From: Paul Cann <Paul.Cann@arun.gov.uk>
Sent: 17 June 2022 10:06
To: Planning.Responses <Planning.Responses@arun.gov.uk>
Cc: Kevin Macknay [REDACTED] David Easton <David.Easton@arun.gov.uk>
Subject: RE: Planning Consultation on: A/91/22/DOC

Application No: A/91/22/DOC
Registered: 5th May 2022
Site Address: Land North of Water Lane and South of A27 Angmering BN16 4EU
Description of Works: Approval of details reserved by condition imposed under A/40/18/OUT relating to condition 41-access works to Water Lane.

Drawing:
2003033-S278-P03-00001

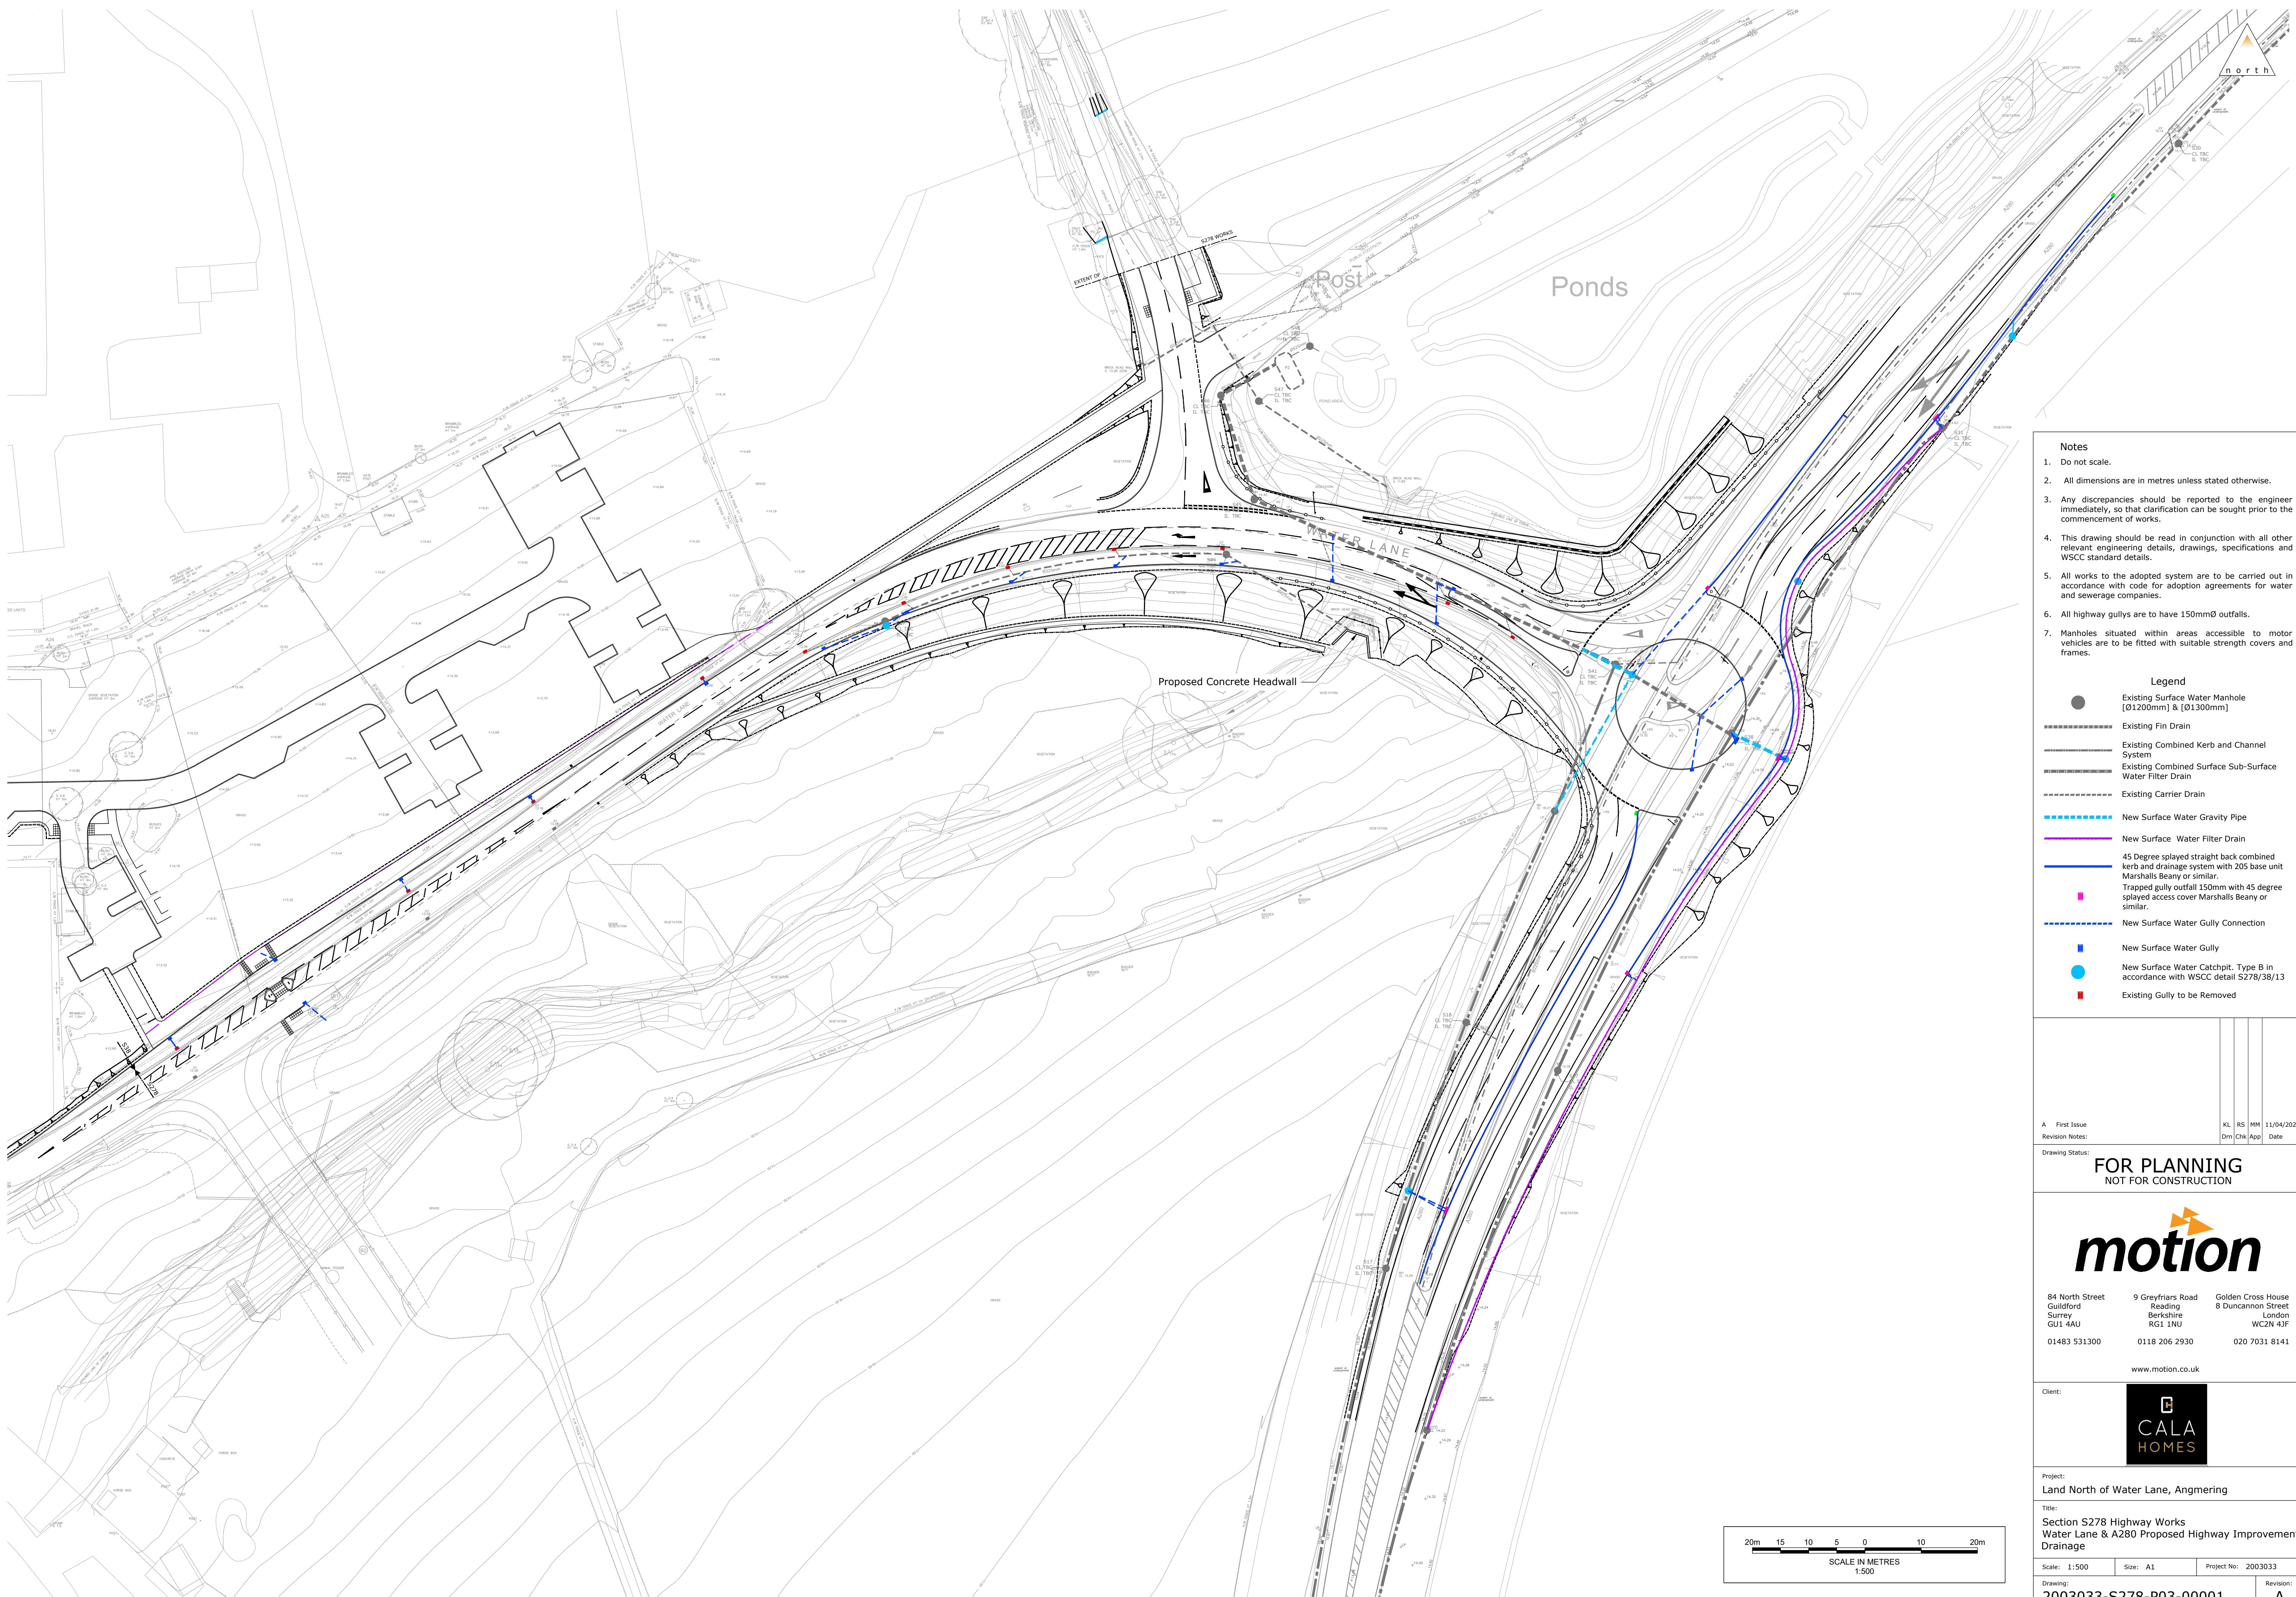
1. There is a known highway flooding issue at the junction of Water Lane and the existing access road to the race track. If the comments below are considered and along with the drainage improvements that are planned in association with the housing development scheme, it is hoped that this issue can be eliminated.

2. The existing highways balancing pond immediately adjacent to these works has suffered a lack of maintenance for many years and its capacity may be compromised. WSCC need to satisfy themselves that the road scheme, the pond issues and any increases in impermeable areas will not increase flood risk.

3. It should be noted that the culverted watercourse (225mm diameter) that passes under the development access road spur (spur forms part of these works) may require upgrading. This is a matter being discussed with the developer's engineers.

4. The reconstruction of the downstream headwall on the Water Lane culvert will require Land Drainage Consent from ourselves.
5. A ditch is believed to exist at the toe of the existing A280 embankment (ie. south east side of road). It is unclear how this is affected by the new embankment of the roundabout. This will need to be discussed and Land Drainage Consent sought for any necessary modifications to the ditch.
